THE ANGMERING SOCIETY

PLANNING APPLICATION A/71/11 and A/76/11
200 New Place Farm, Angmering
Provision of Ground Floor Conservatory

DRAWING TITLE
Proposed Plans,
and Section

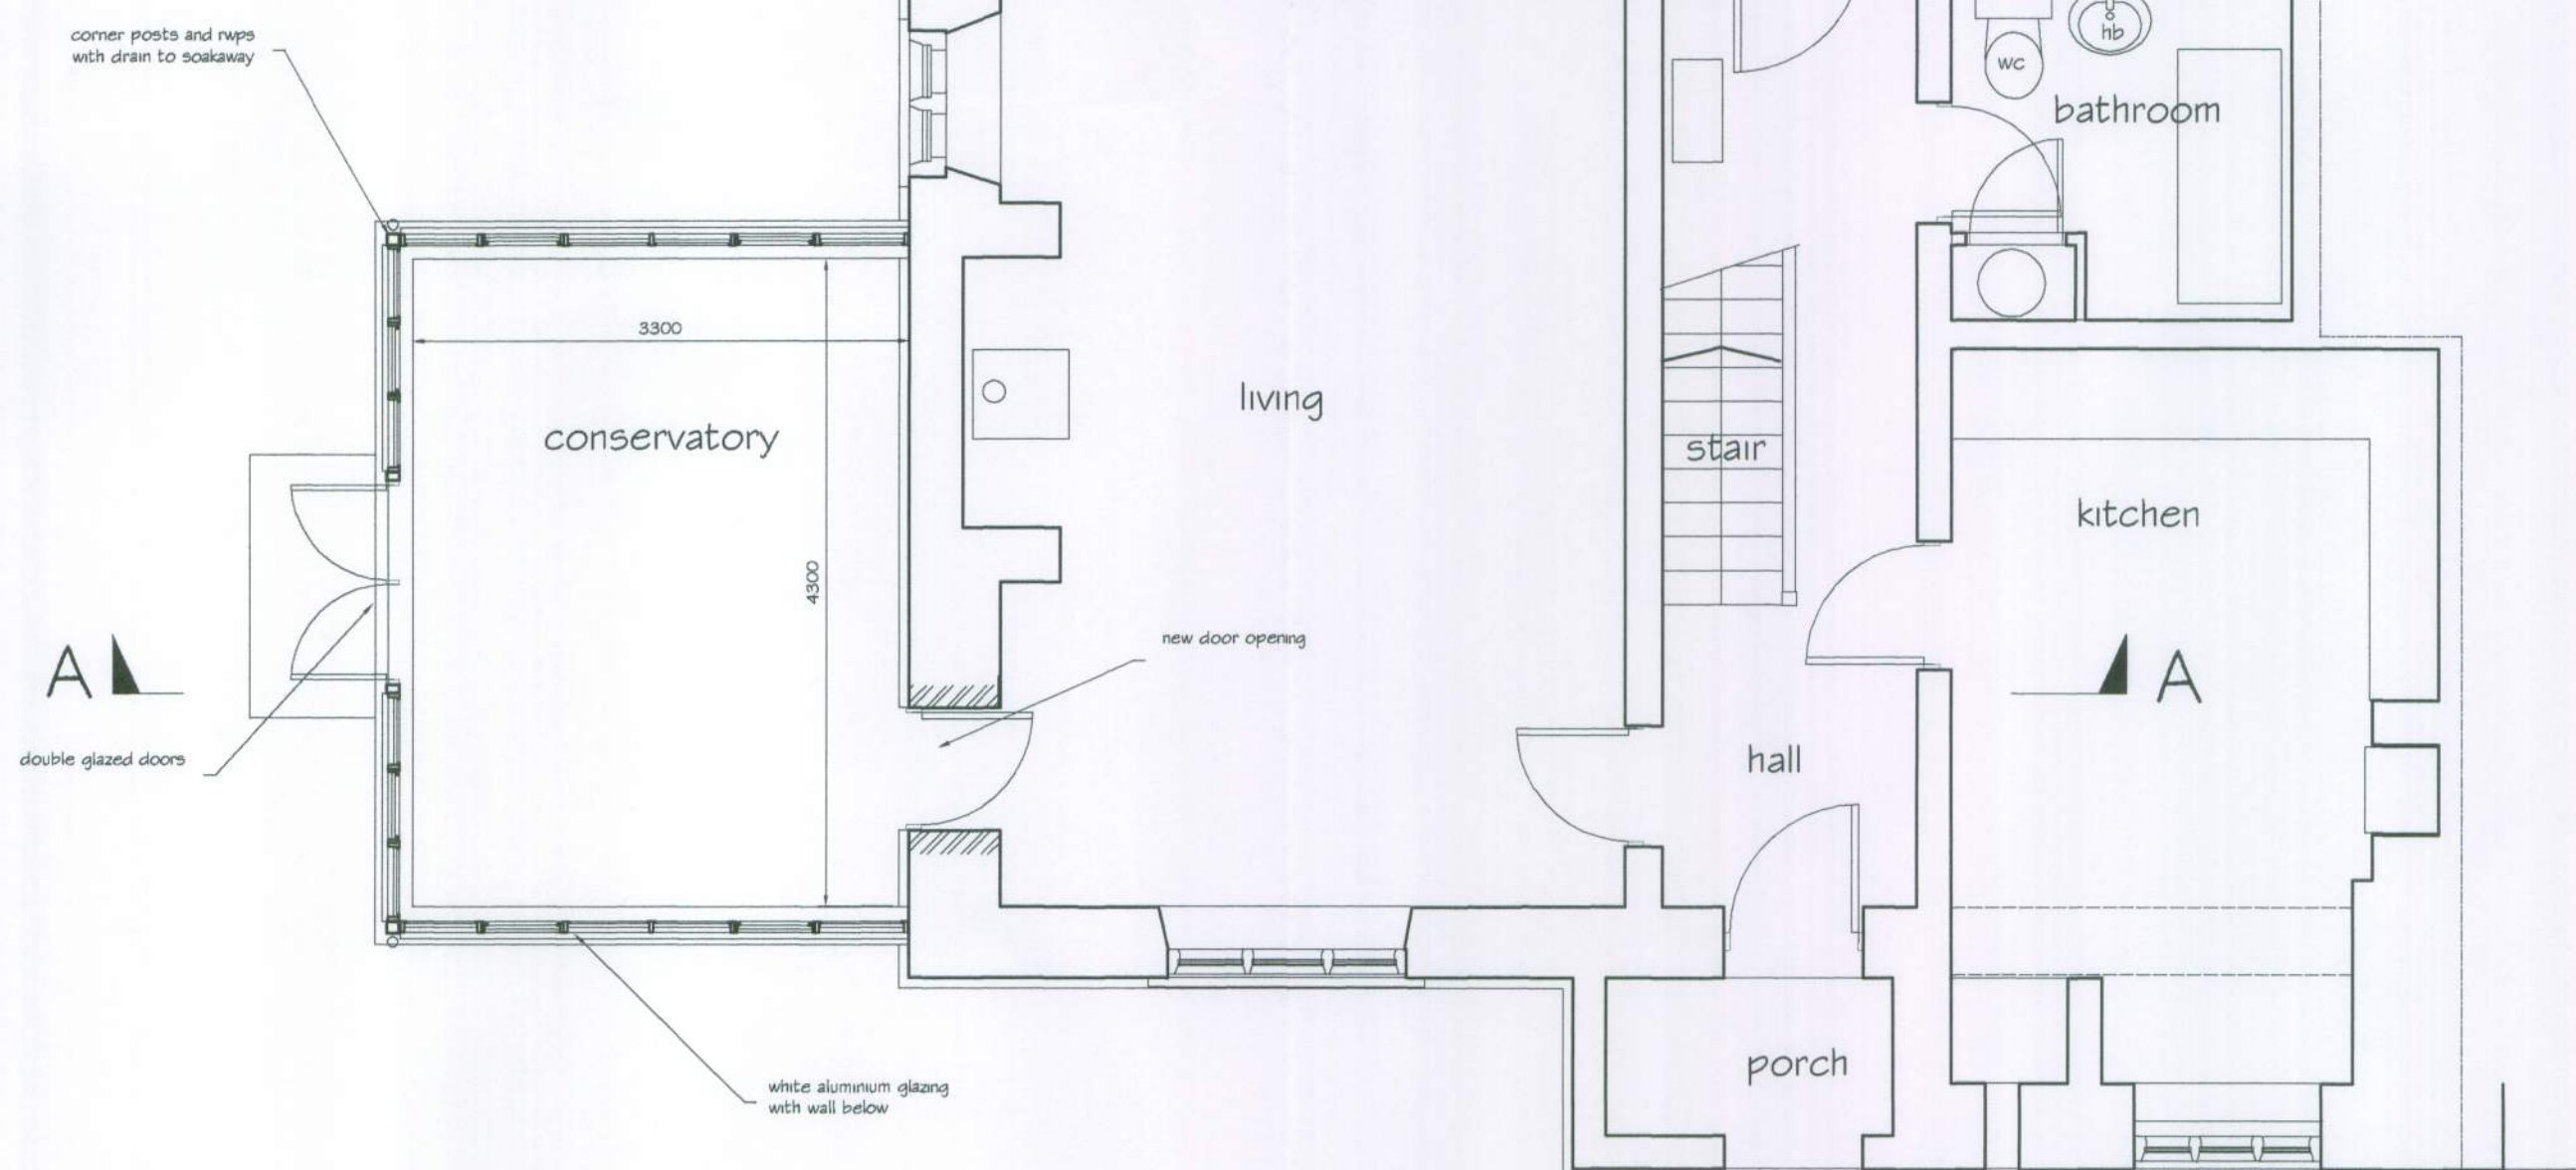
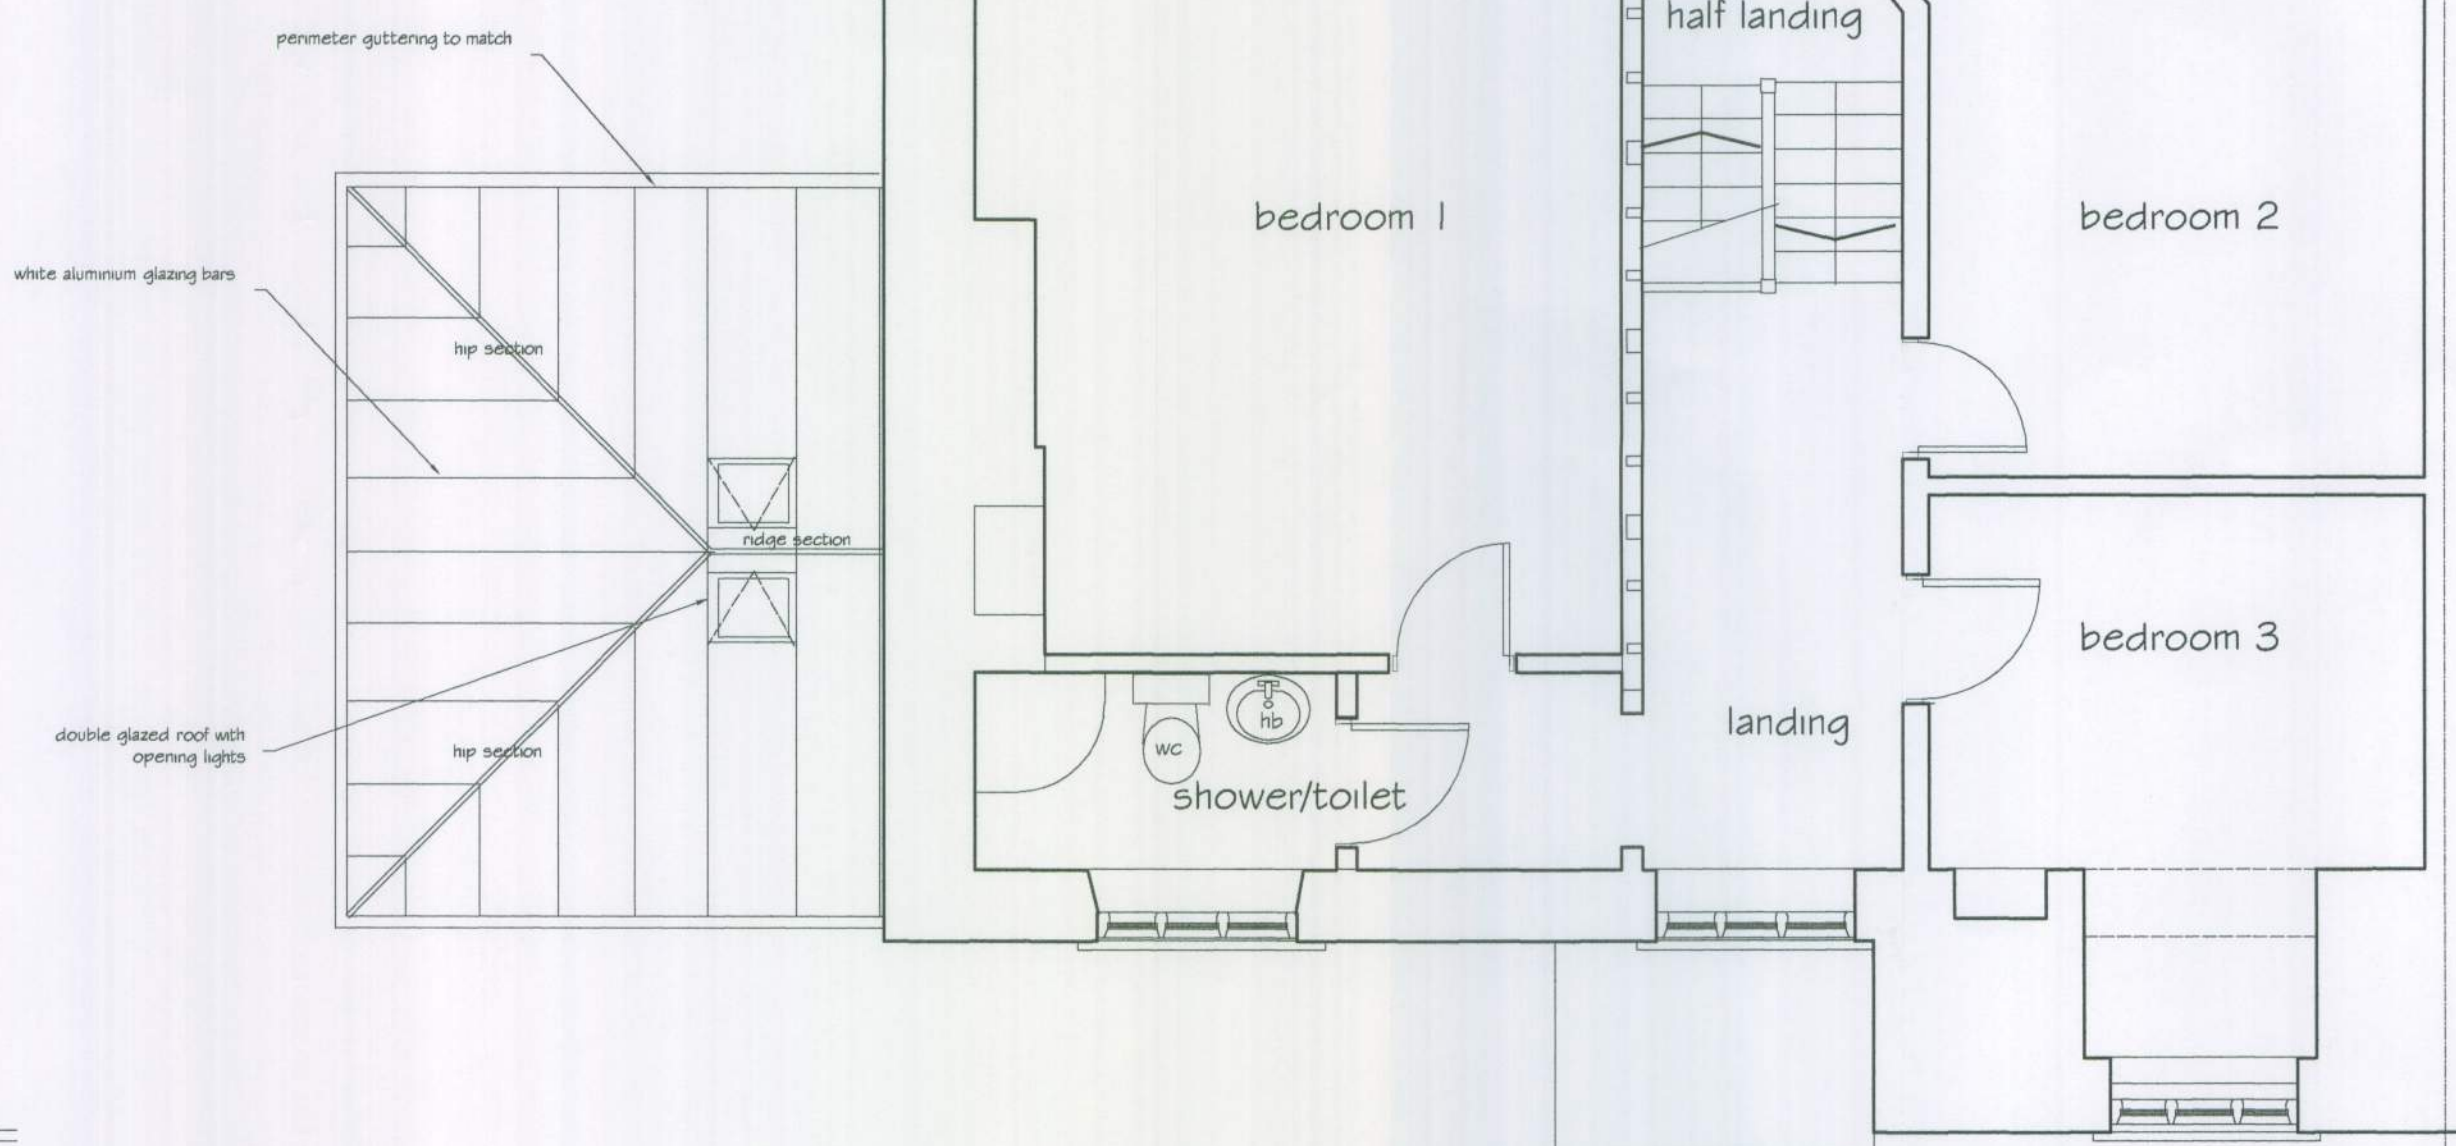
We are minded to suggest that the chosen frame material, aluminium, is entirely inappropriate and that any criteria applicable were the existing window frames being replaced should apply in this instance. A wood frame construction would be preferable.

DRAWING TITLE
Proposed Elevations

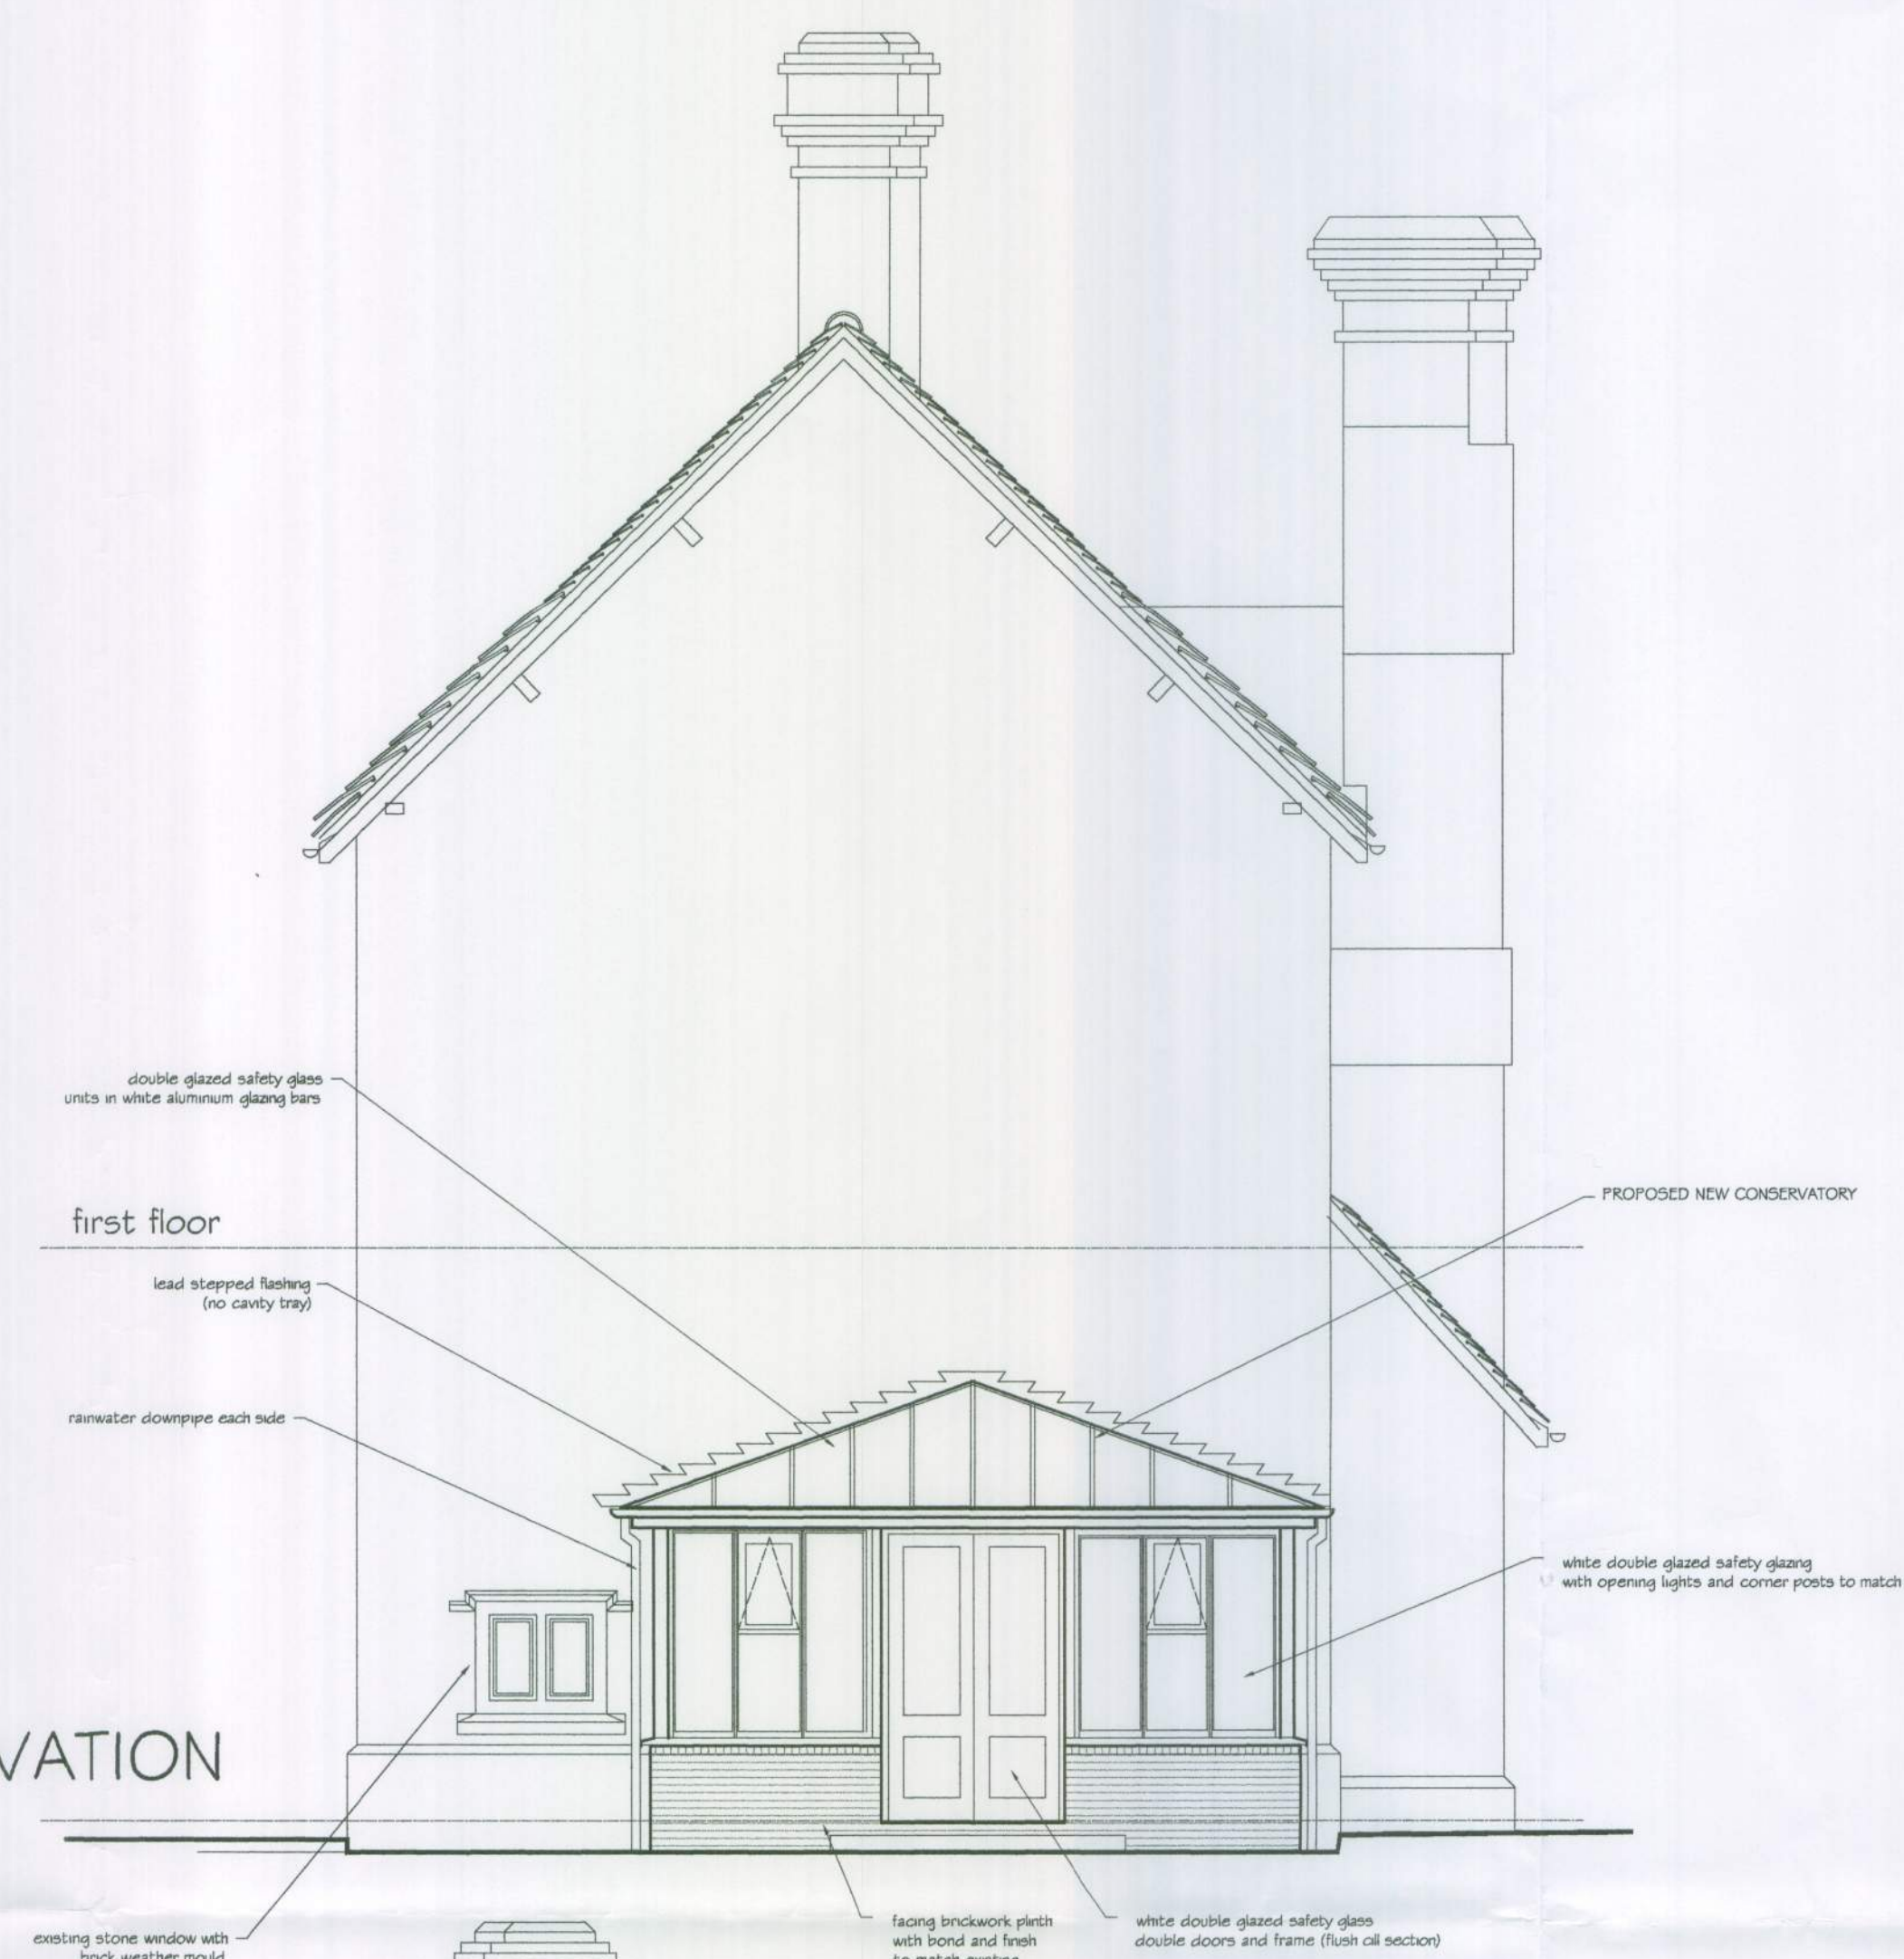
Regarding design and visual impact, taking account of the scale and architectural detail of the existing structure, a roof ridge in line with the top of the pitched roofing either side of the chimney breast projection on the North Elevation would, though of greater visual impact, result in a finished project in harmony with, rather than detracting from the existing.
